LSC Responses to TIS Redline Comments

Sterling Ranch East Filing 5 Preliminary Plan (LSC# S234180)

Figure 6b
 Short-Term Background Traffic

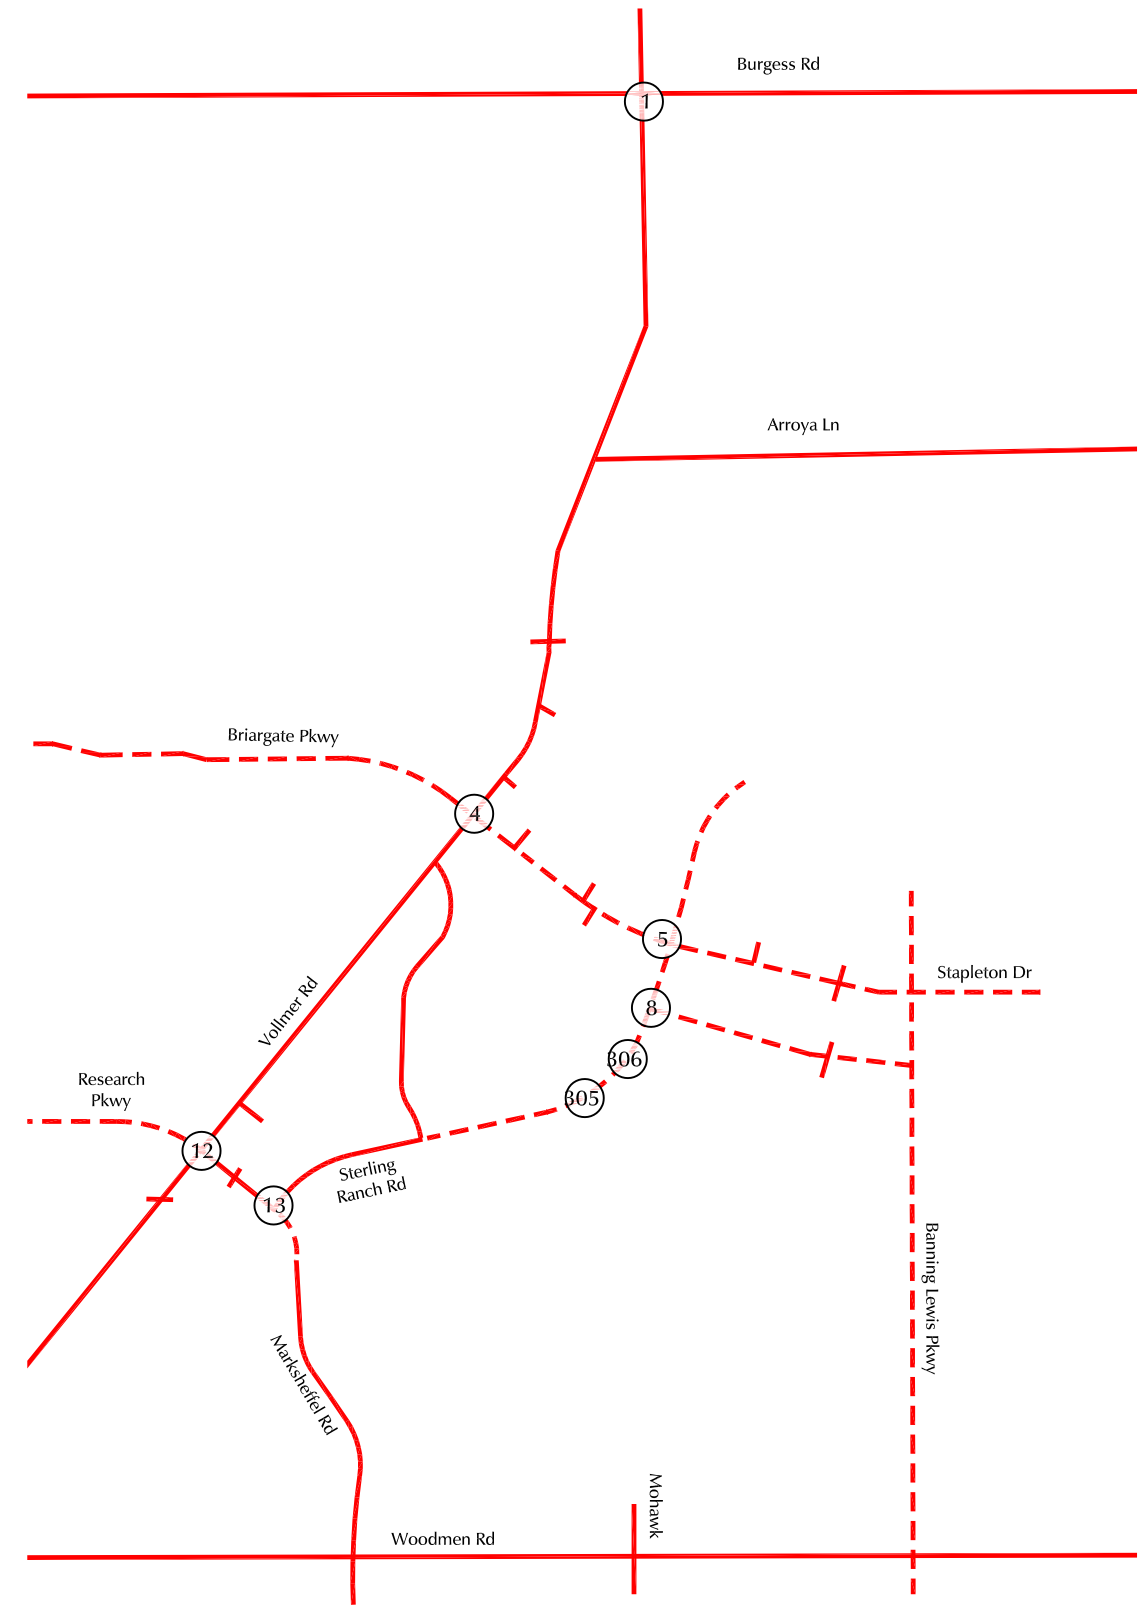
Unresolved: Figure 6b shows traffic generated from surrounding filings. Please revise values that are 0 or provide clarification in the narrative.

LSC Response: The narrative has been revised to clarify that the short-term background traffic only includes traffic generated by the approved filings (Filings 1 and 2) within Sterling Ranch East Preliminary Plan 1.

## Figure 5c

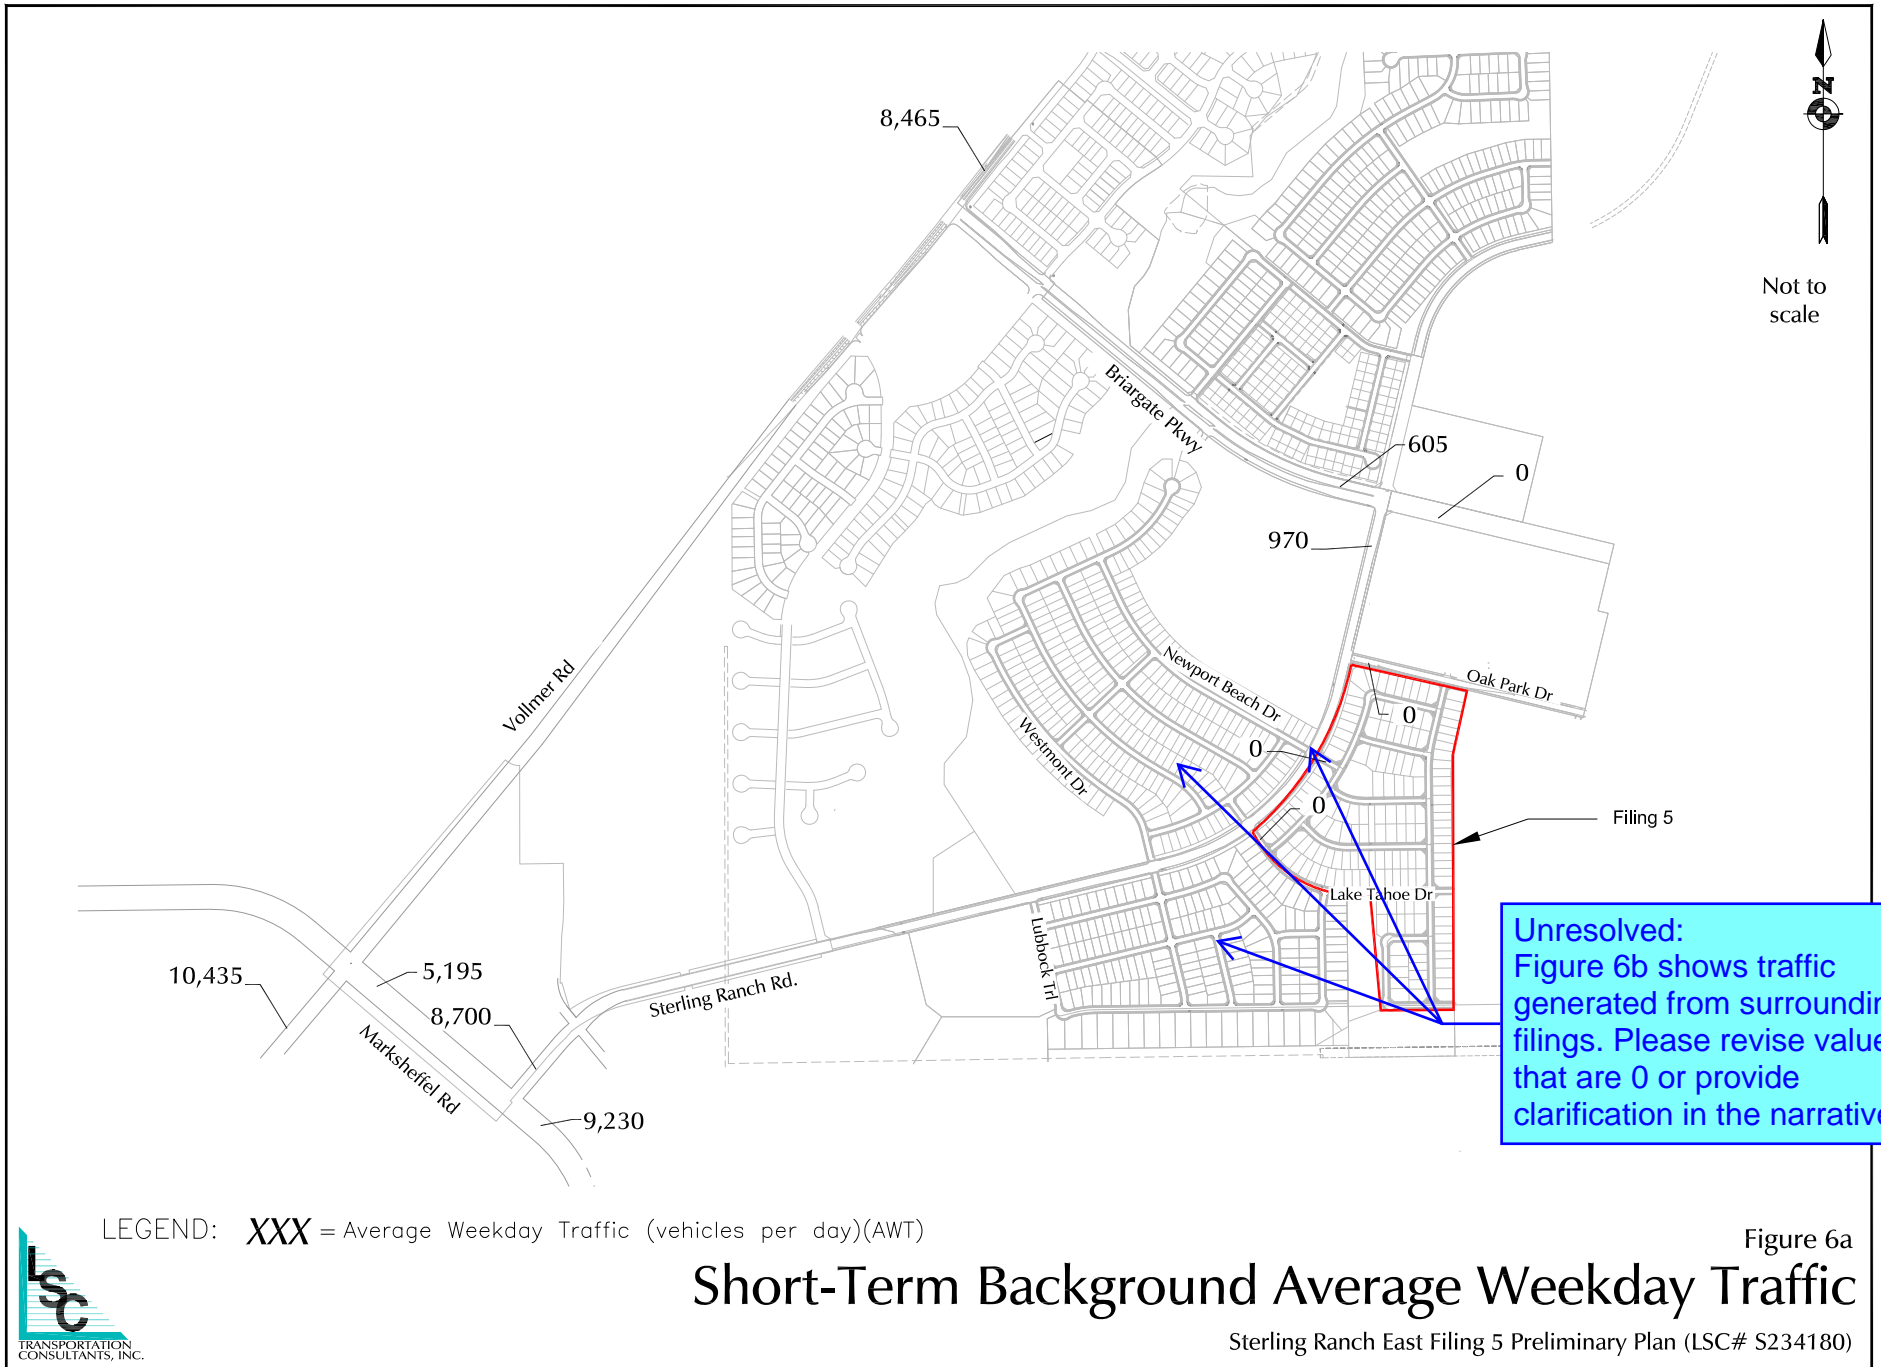
Unresolved: Provide information for these locations.

Author: kdferrin Subject: Sticky Note Date: 1/16/2024 9:03:05 AM
LSC Response: The additional information has been provided as requested.
